**Consultation Response from KC,
Highways Development Management**

2026/90840 9, Bow Street, Springwood, Huddersfield, HD1 4BJ

Change of use of dwelling to House of Multiple Occupation and internal works

Date Responded: 27/05/2026

**1 Proposed Ground Floor**  
 1 : 50

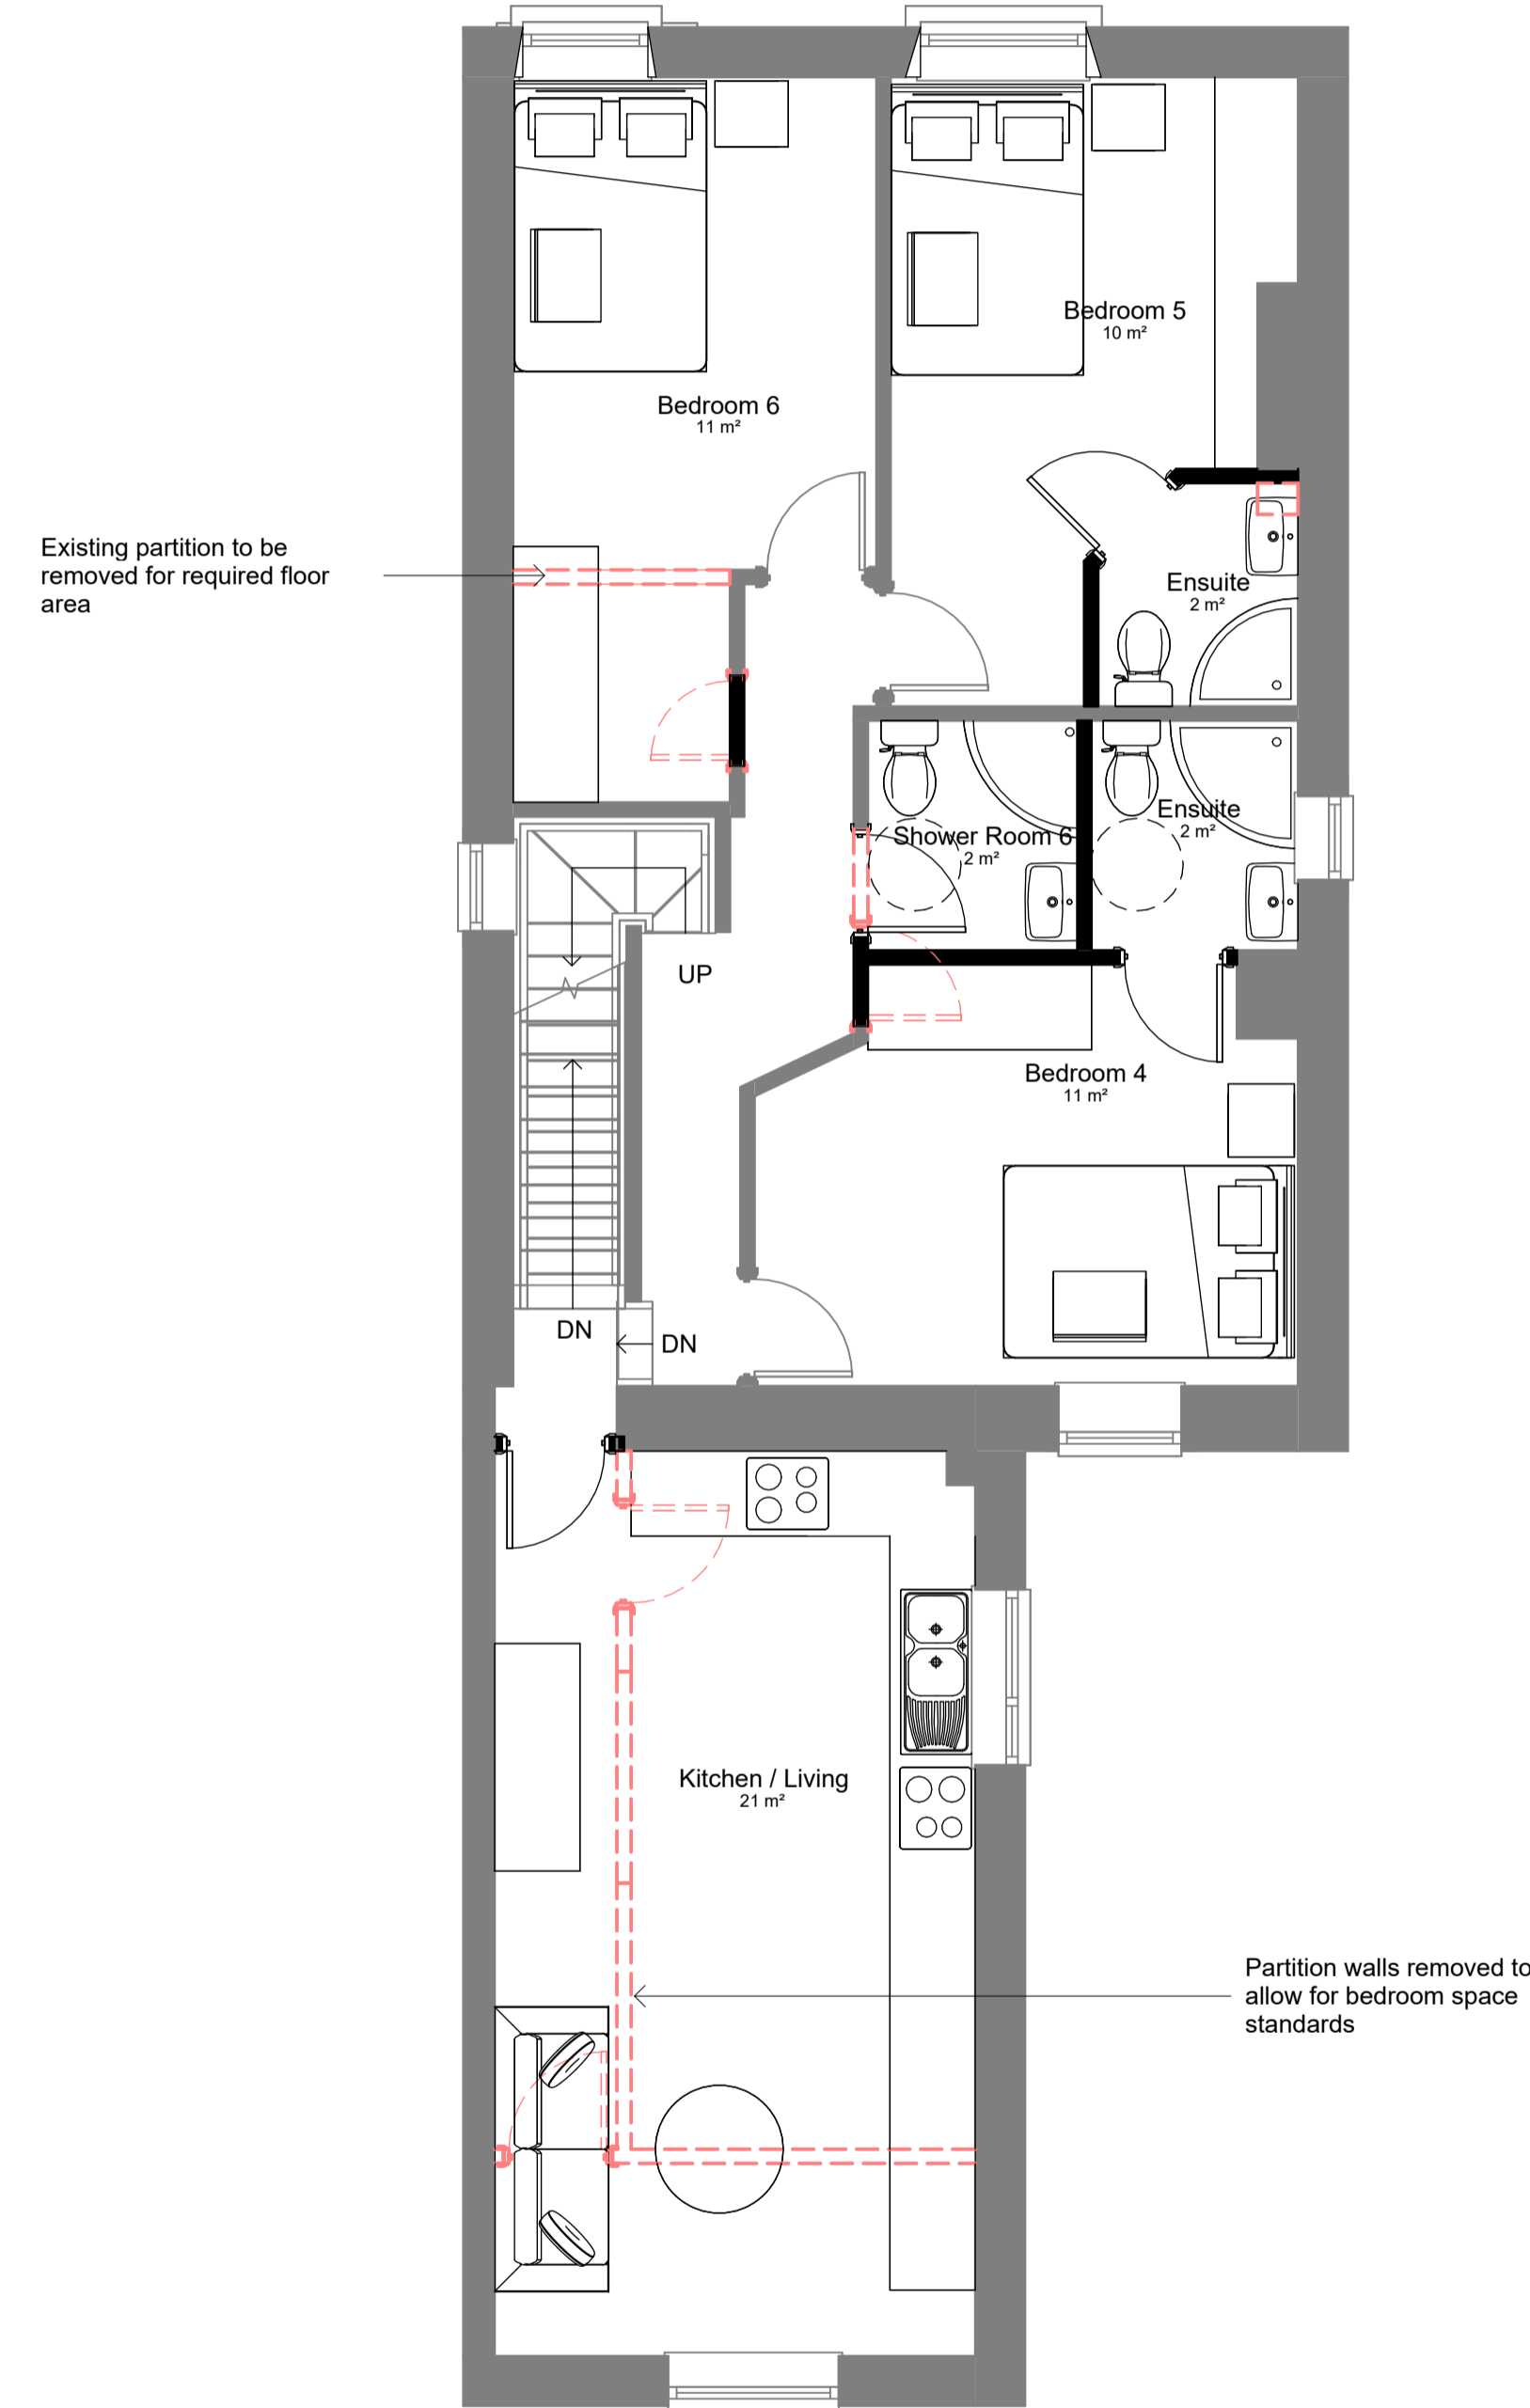
Parking is proposed for up to 5 vehicles however, the layout is impractical and incompatible with a large household of non-related occupants, with the majority of vehicles effectively blocked in by others.

In reality I wouldn't expect more than a couple of vehicles being able to use the drive.

A bin presentation point will be required close to the adopted highway that does not obstruct access or the adopted highway, and this may impact on the proposed parking provision further.
